Project Name: MONTE VISTA ADDITION

**CITY OF ALBUQUERQUE
PLANNING DEPARTMENT
December 14, 2011
DRB Comments**

PROJECT # 1009058

RE: Lot A, Block 38, Monte Vista Addition

Sketch Plat
Lot A-1, Block 38
 Being a Replat of Lot A, Block 38
Monte Vista Addition
 Bernalillo County, New Mexico
 City of Albuquerque
 November 2011

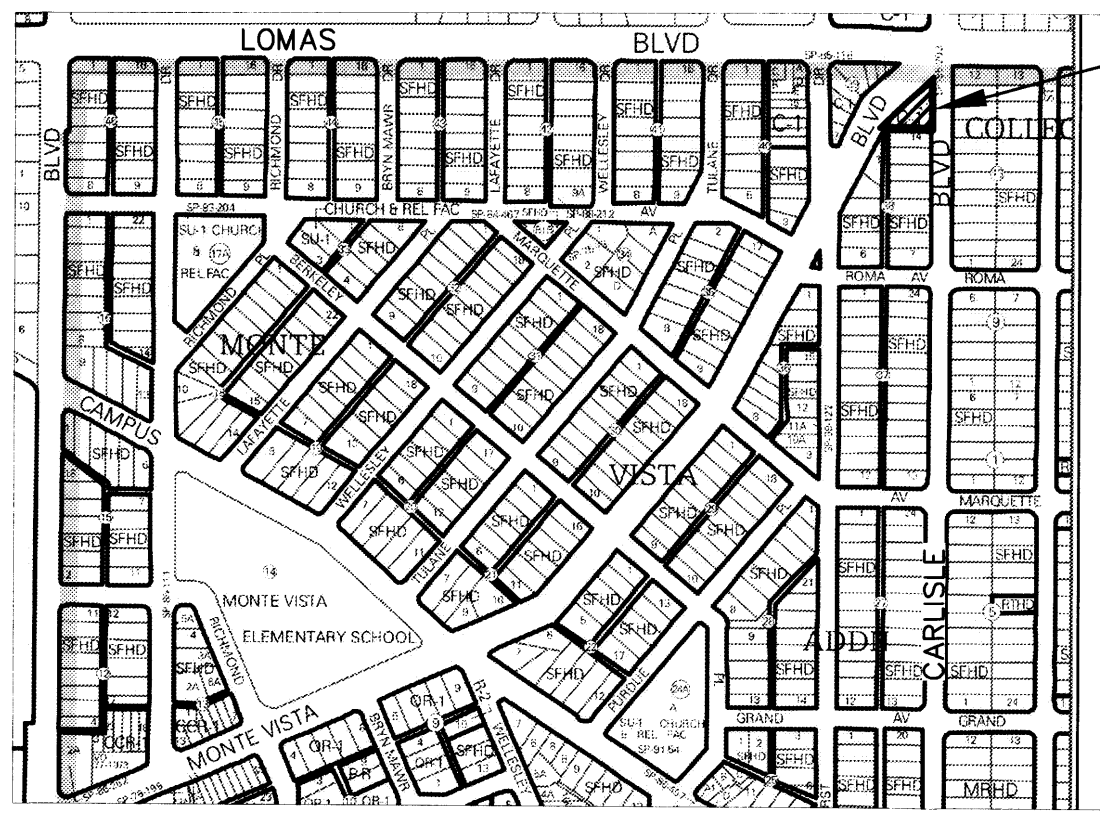
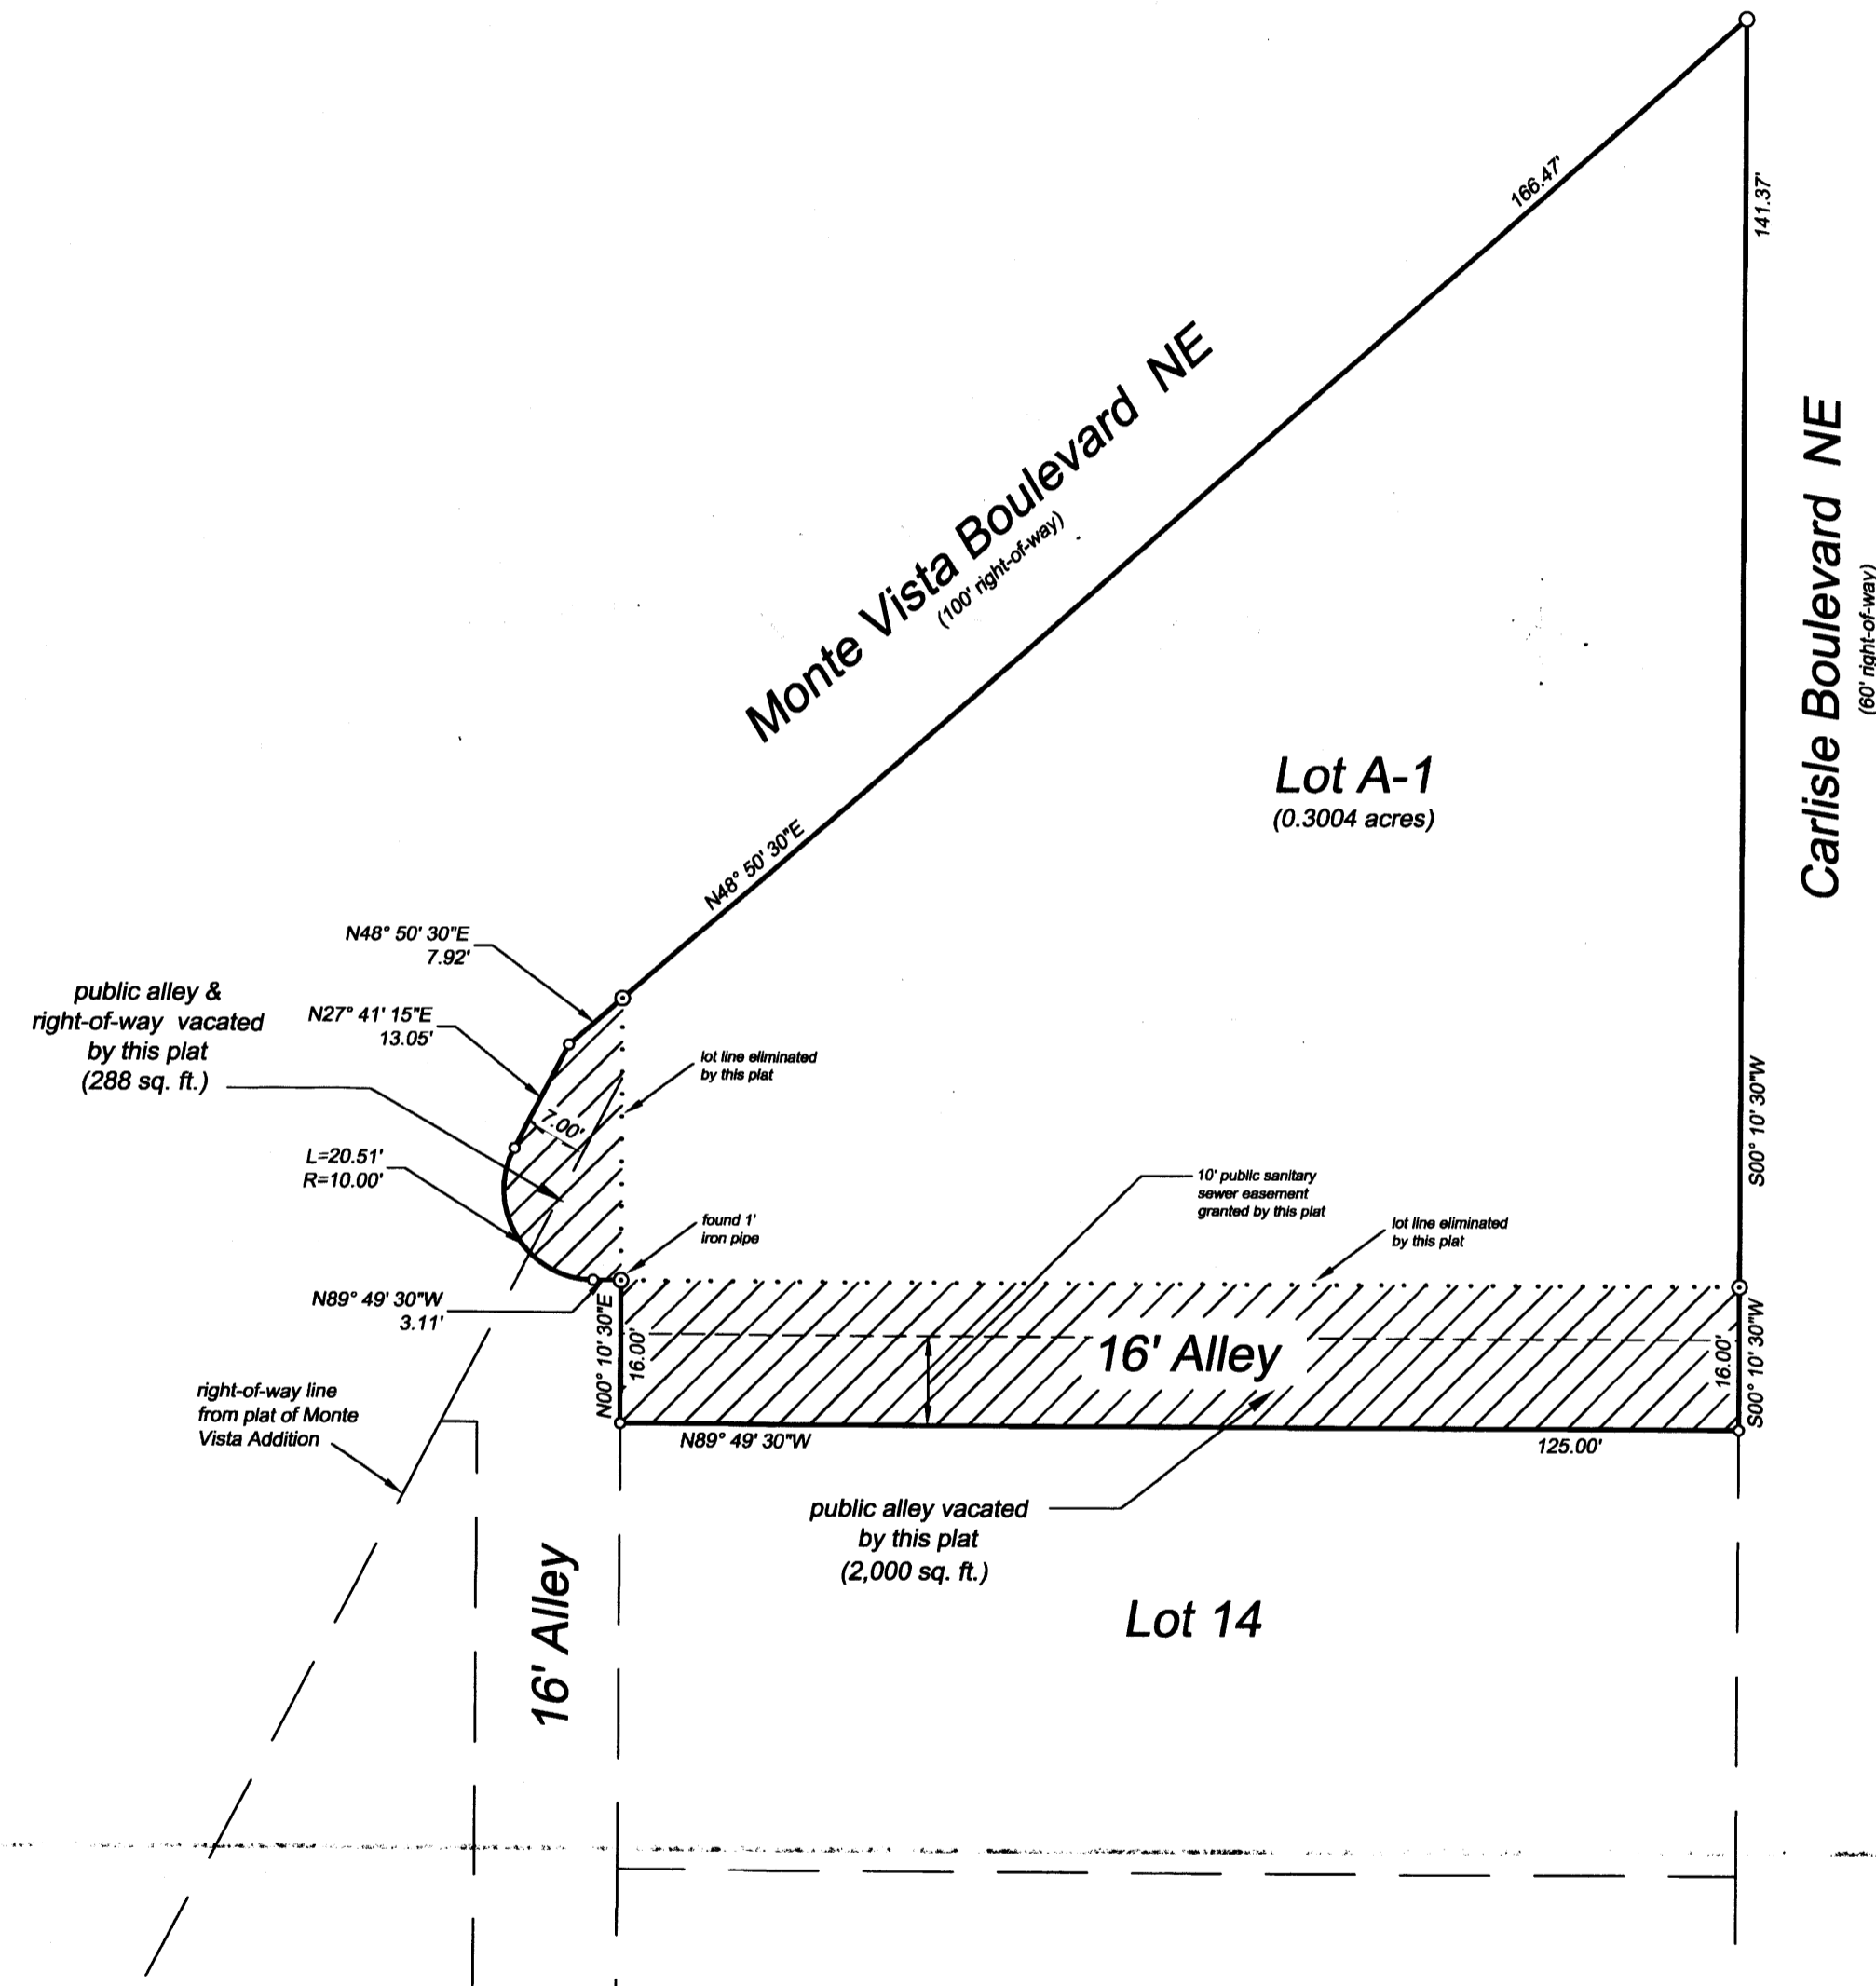
Refer to comments from Transportation Development regarding proposed vacation. If approved, that should be included in the legal description. While the full right of way can be replatted into Lot A with approval of adjacent lot, the zone boundaries automatically extend to the centerline of the alley – a “Zone Boundary Line” will need to be shown on the plat along the former alley centerline.
